Appeal Decision

Appeal Ref: APP/R5510/D/24/3336987

42 Halford Road, Ickenham, Hillingdon, UB10 8PZ

- The appeal is made under section 78 of the Town and Country Planning Act 1990 against a refusal to grant planning permission.
- The appeal is made by Mr Chiraag against the decision of the Council of the London Borough of Hillingdon.
- The application Ref 21435/APP/2023/3152, dated 31 October 2023, was refused by notice dated 27 December 2023.
- The development proposed is front infill extension, 2m rear extension and internal alterations.

Proposed Roof Plan

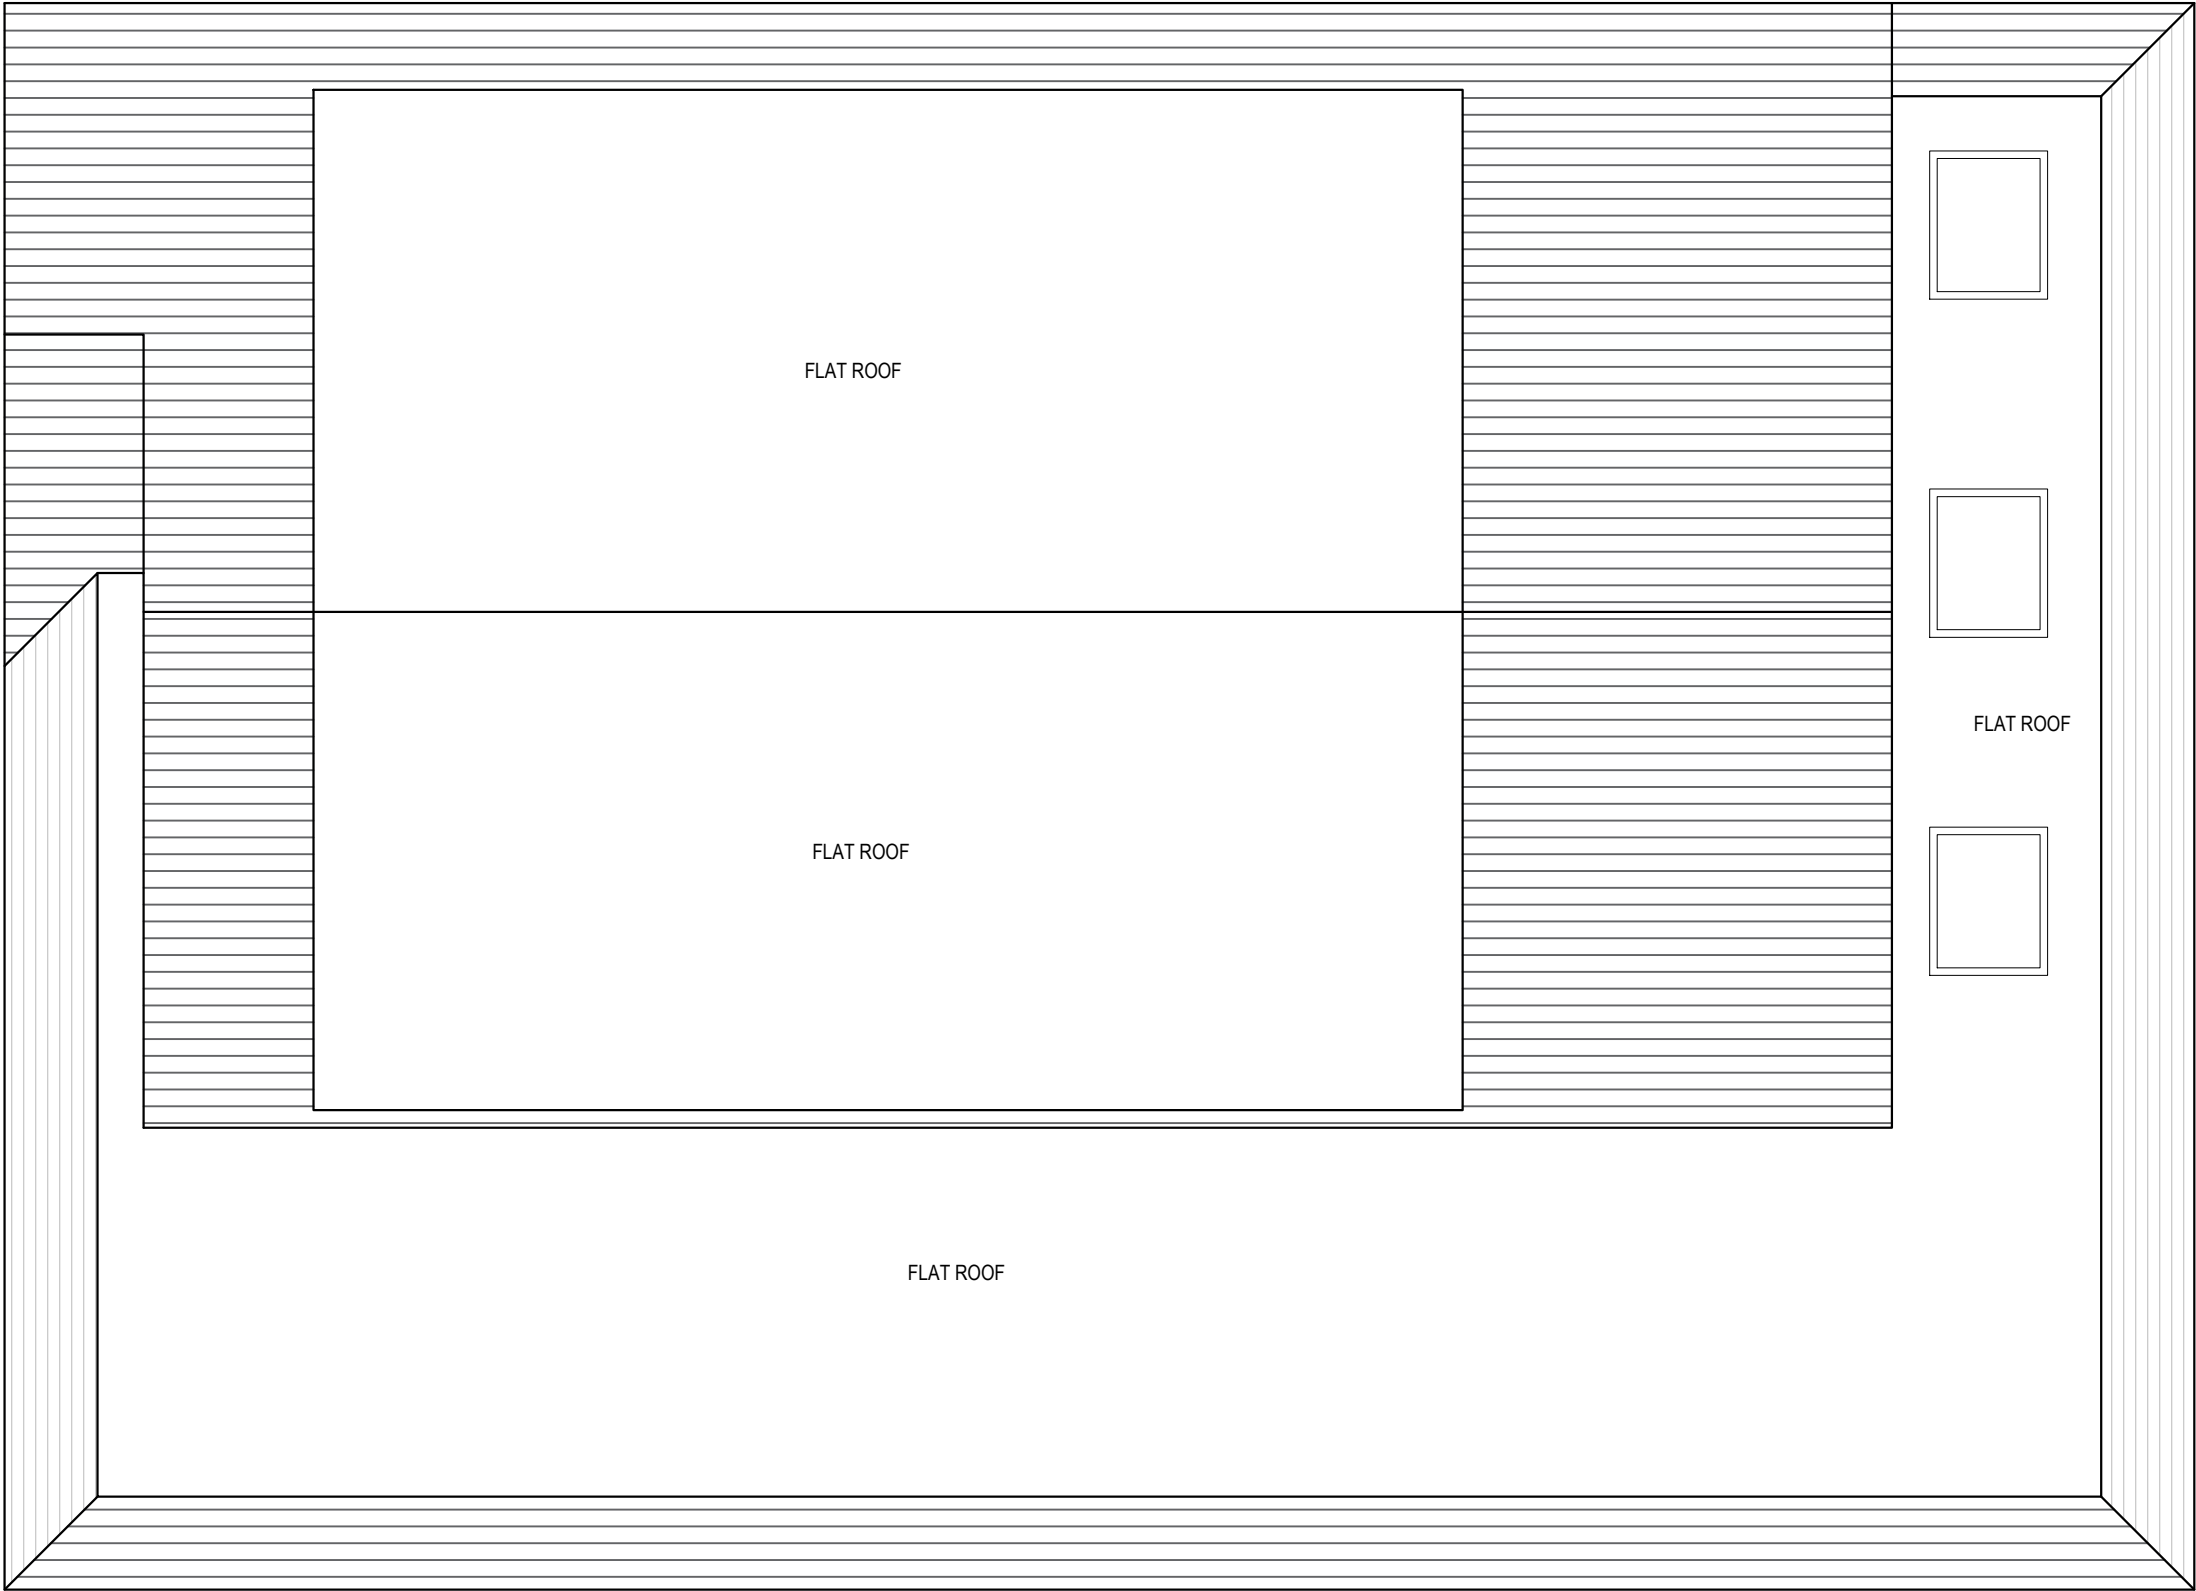
5. I consider that the design, size and siting of the proposed extension would appear incongruous and out of keeping with the existing building itself and the wider street scene. Although it would be subservient to the building, the front element extending across from the projecting gable to wrap around to the existing side extension with its pitched/crown roof would appear as an awkward

addition in the context of the clean lines of the main architectural style of the building. The latter is already compromised by the existing large side dormers and the cumulative effect of the proposal and the dormers would result in a number of poorly integrated features which would detract from the character and appearance of the host building as a whole.

Proposed Elevations

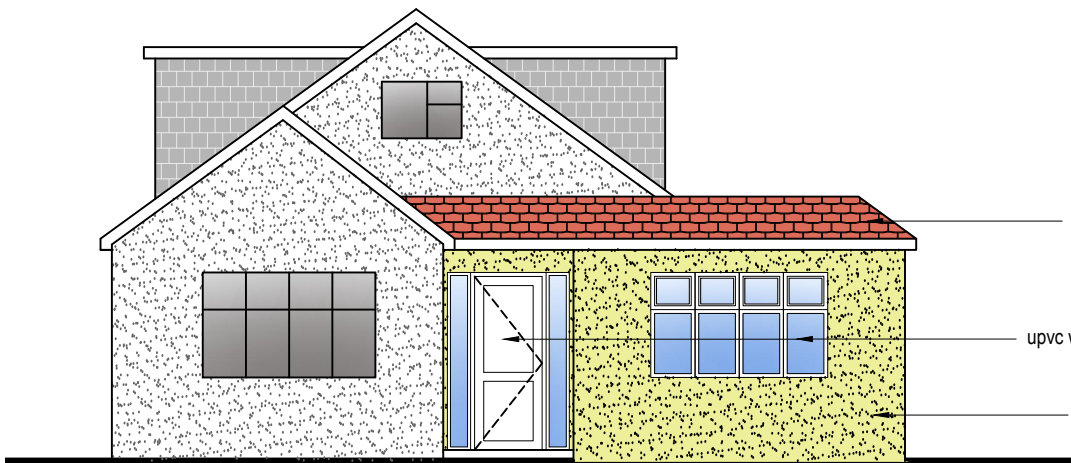
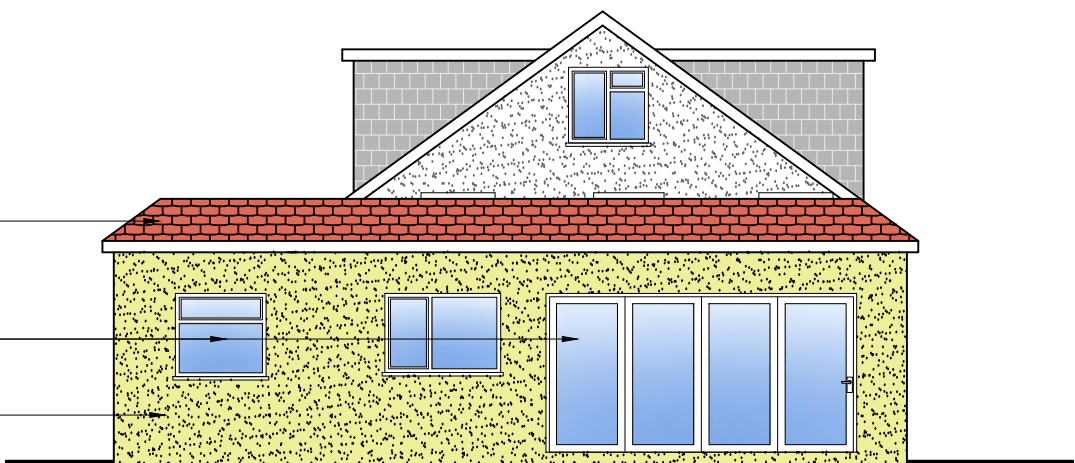
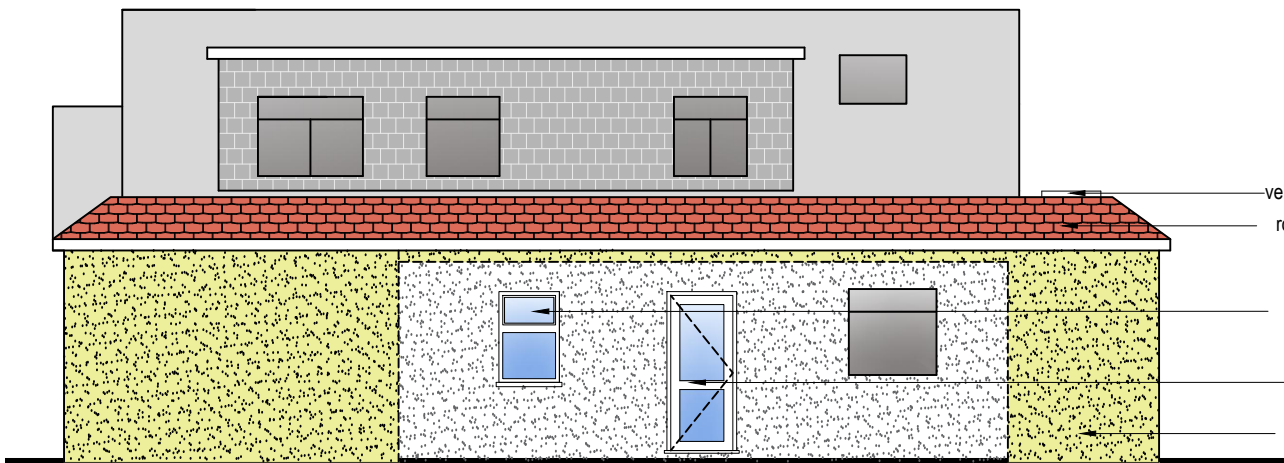
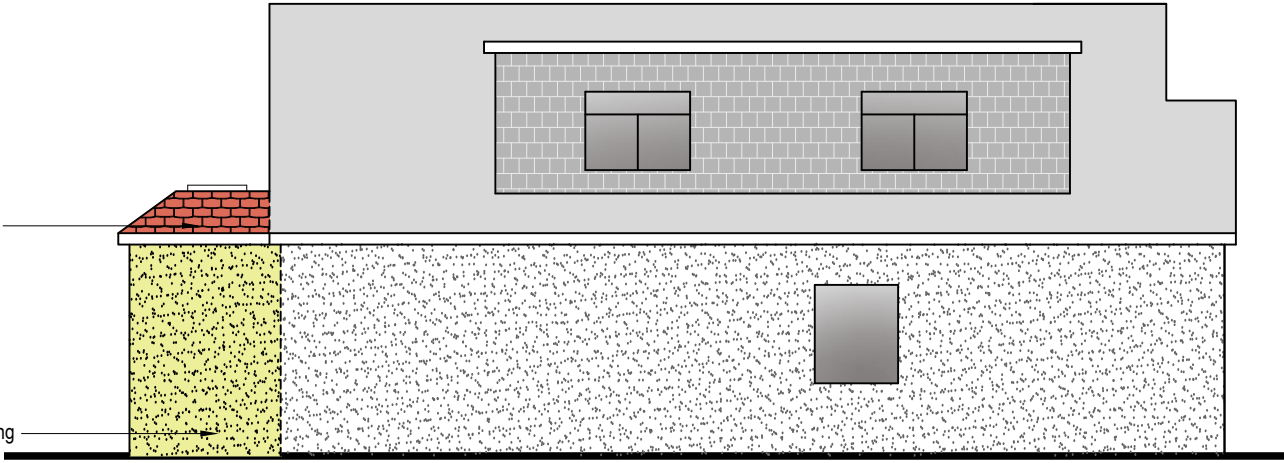
6. Many properties nearby have been extended and altered in a variety of ways but the prominent front gables remain as a highly visible feature along the street. There are a few examples of pitched roof front extensions/canopies across front elevations nearby, but I consider that these do not relate well to the original form of the host buildings and do not make a positive contribution to the street scene. They do not weigh in favour of this appeal.
7. I conclude that the proposed extension would harm the character and appearance of the existing building and the wider street scene, contrary to policies BE1, DMHB11 and DMHD1 of the local plan and D3 of the London Plan.

Proposed Ground Floor Plan

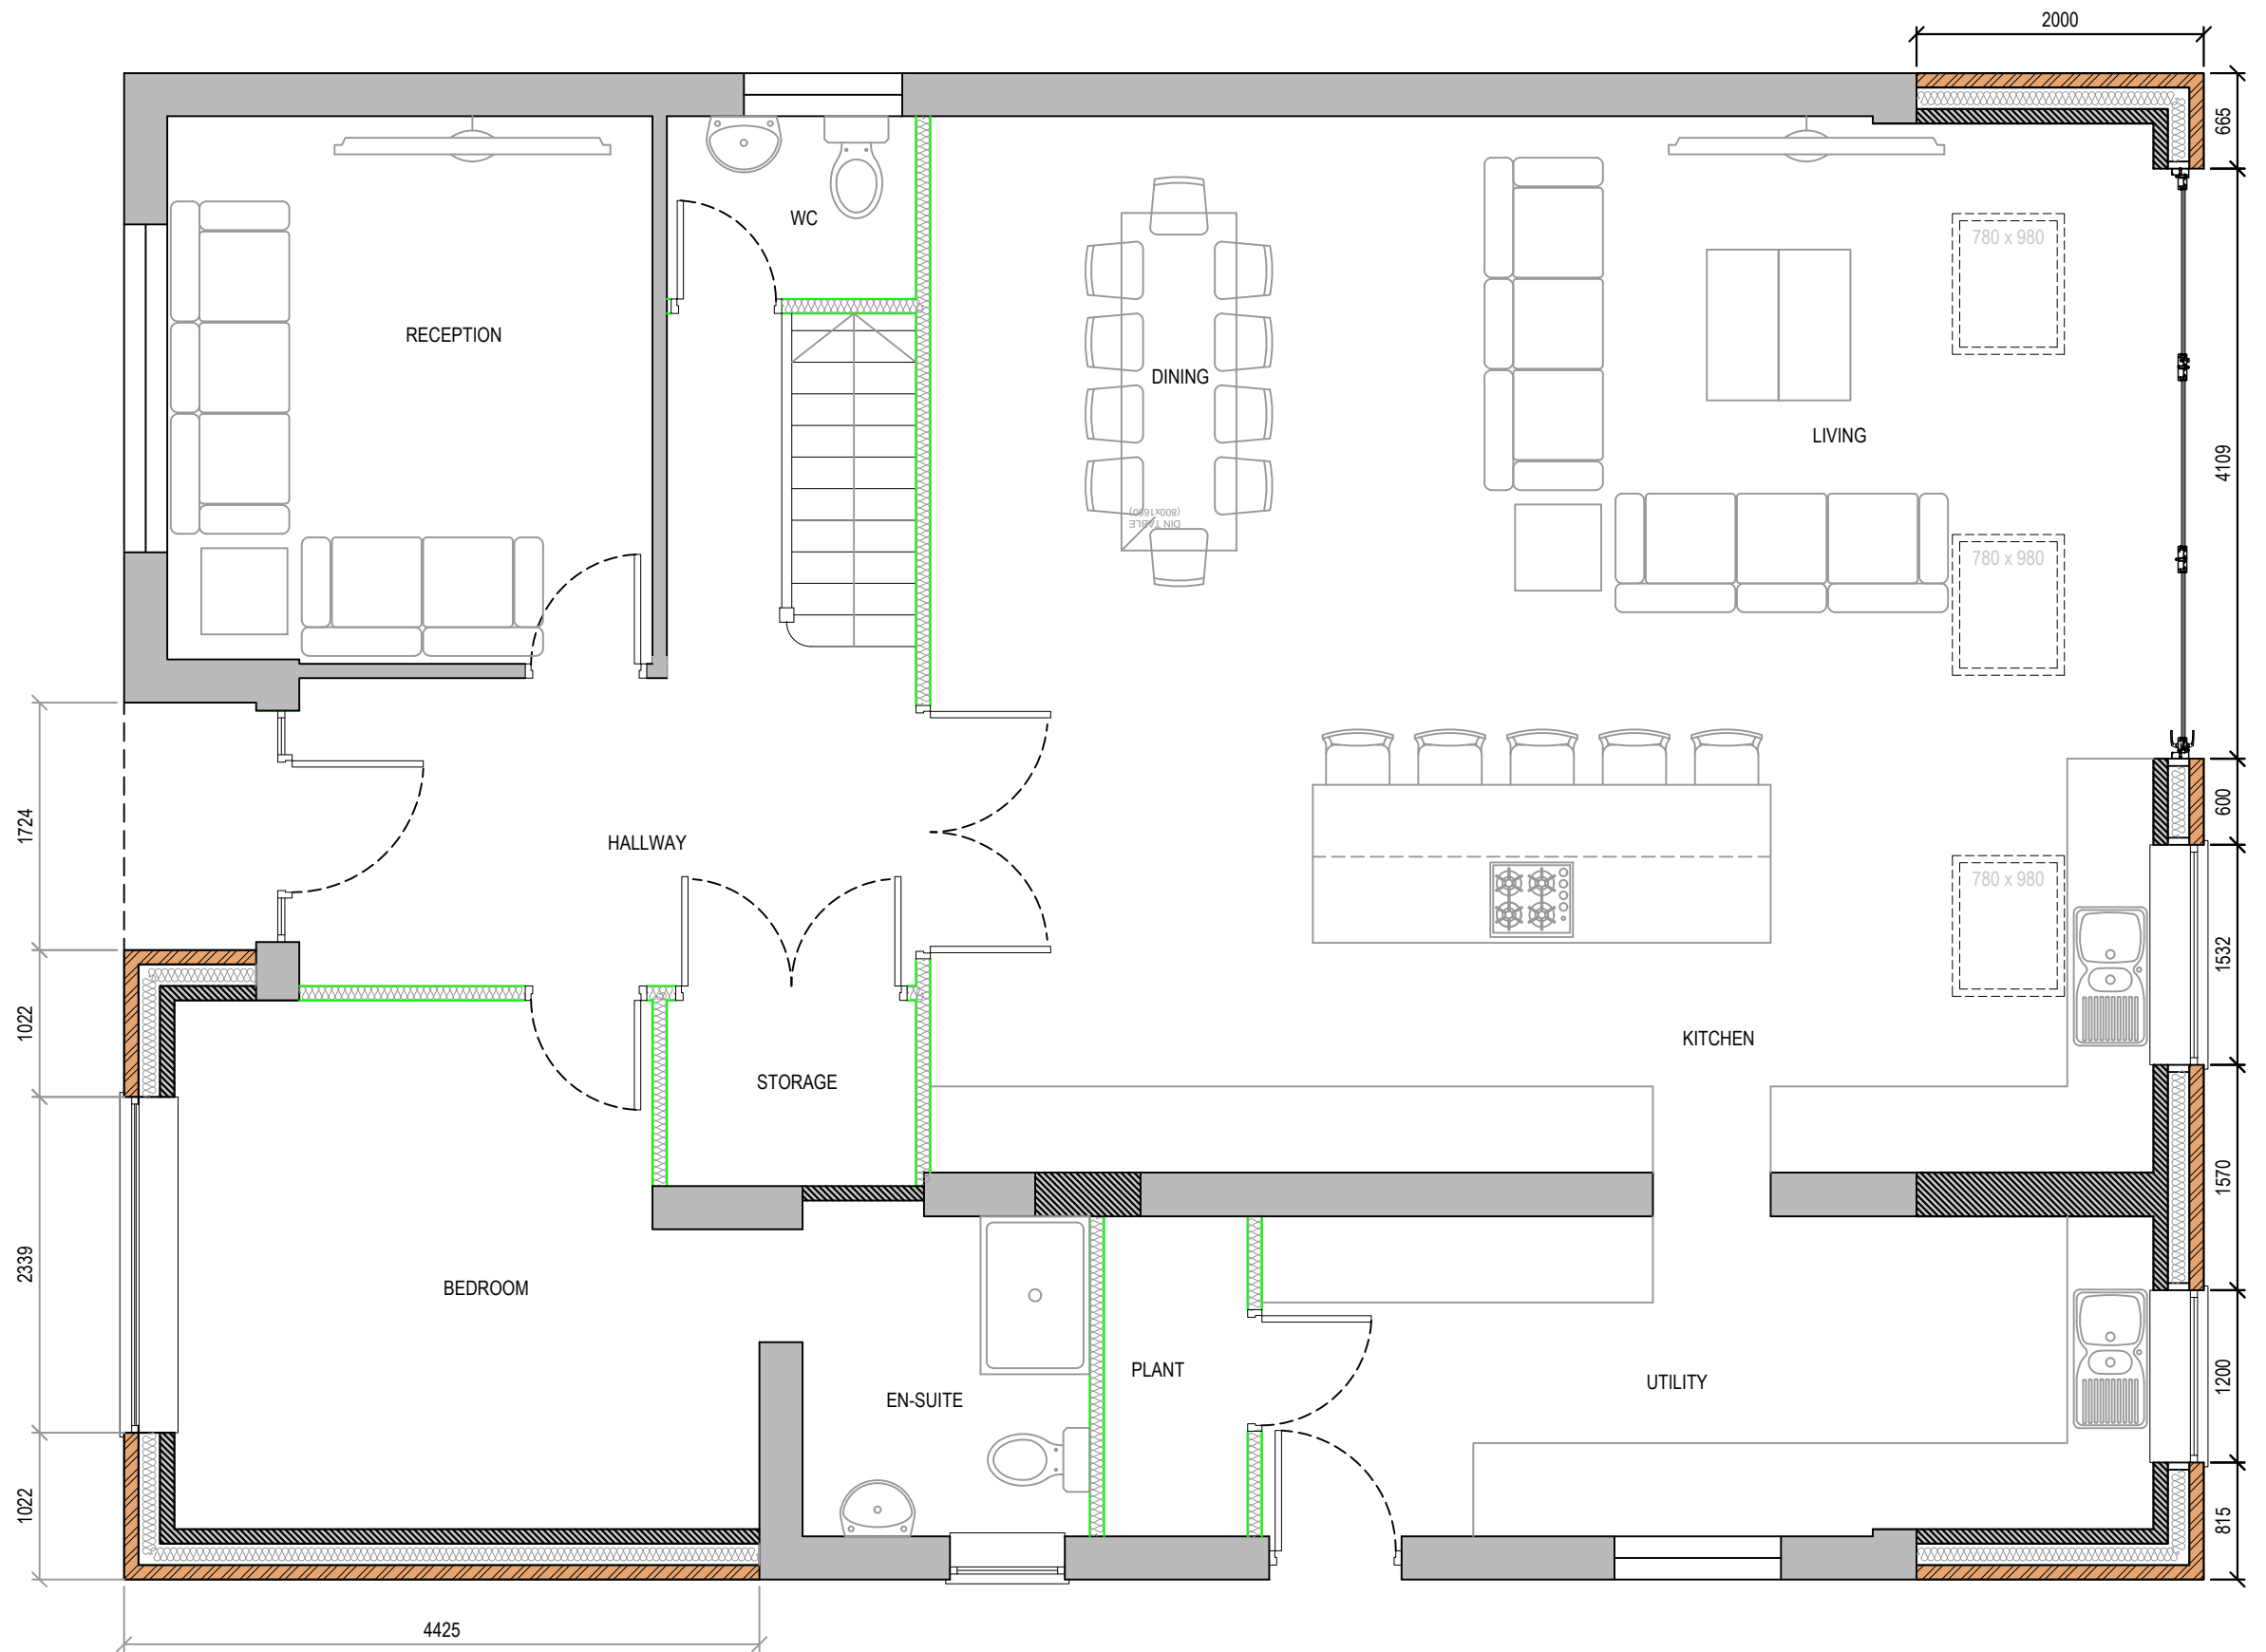
8. The property has previously had a full height rear extension and the proposal would include an additional full width single storey extension to the rear. The neighbouring property, No. 40 to the east is on a staggered building line with No. 42, such that the rear part of the latter, as extended, would project approximately 10m beyond the rear elevation of No. 40. The latter is located very close to the common boundary and has a relatively small garden and a somewhat restricted outlook. I consider that the extension of the proposed rear element into the garden of approximately 2m would result in an adverse impact on the outlook from that property, in that it would cause some increase in the sense of enclosure in the latter and some additional loss of afternoon sunlight. However, I consider that although the impact of this on the occupiers of No. 40 would not be sufficient on its own to dismiss the appeal it adds some weight against it.

9. The rear building line of No. 44 to the west is set back from that of No.42 such that the proposal would result in an overall projection of approximately 4.5m beyond the rear elevation of No. 44. I understand that the nearest rear facing windows in No. 44 to the boundary include a utility room and the kitchen. There would be some loss of outlook and sunlight from No. 44, but this would not be sufficient on its own to dismiss the appeal.

10. I conclude that the proposal would result in some harm to the living conditions of neighbouring residents and that in this respect it would be inconsistent with policies DMHB11 and DMHD1.
